URBAN DESIGN REVIEW & PRELODGEEMENT PANEL ADVICE

PROPERTY: Lot 117 Lachlan's Line (6 Halifax Street, Macquarie Park)

PRELODGEEMENT No: PRL NO: PRL2023/0006

DEVELOPMENT: **Proposed Affordable housing development. 9,887sqm of GFA including 13 storeys 38 car parking spaces and total 135 units**

Figure 6: Extract from submitted plans demonstrating the building encroaching the easement

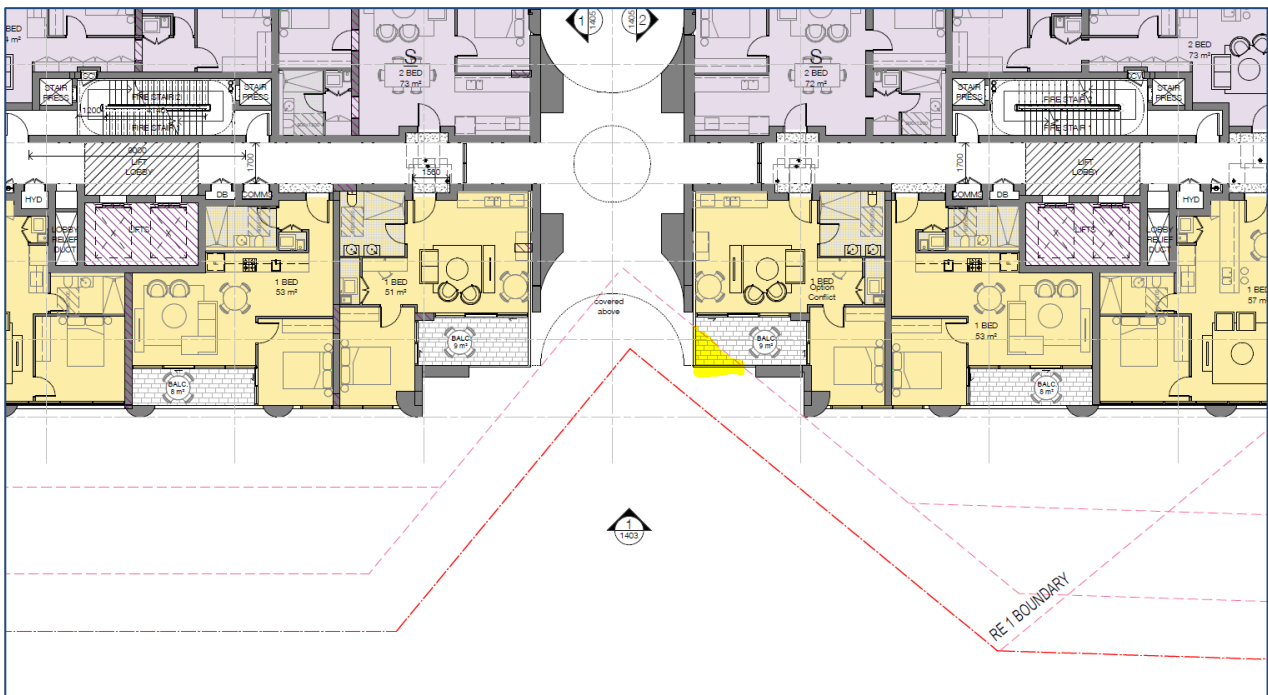
- It appears that the proposed development is encroached into the drainage easement. Please note that any encroachment to the easement must be avoided. Please see Figure 10.

Figure 10: Mark up of submitted plans

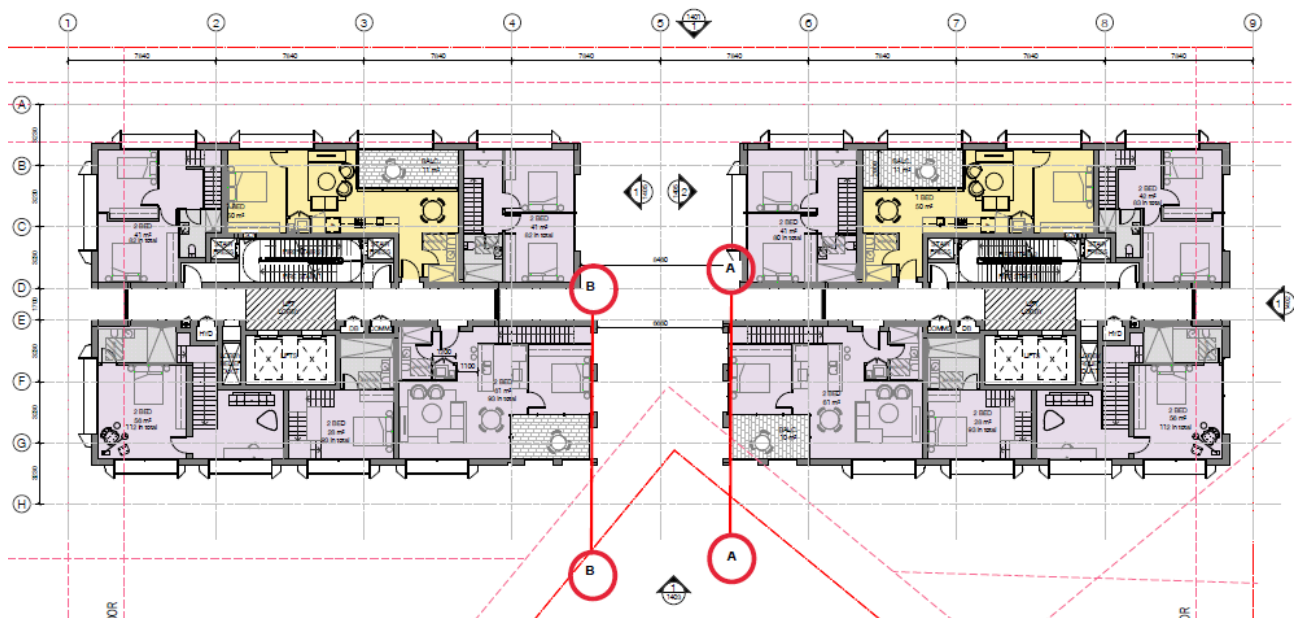
- The proposed development is located adjacent to the Council's drainage system, please demonstrate that the footing of the proposed structure is below the adjacent invert levels of the Council's drainage system therefore no loading is placed on Council's drainage system. In this regard, structural plan must be submitted to Council.
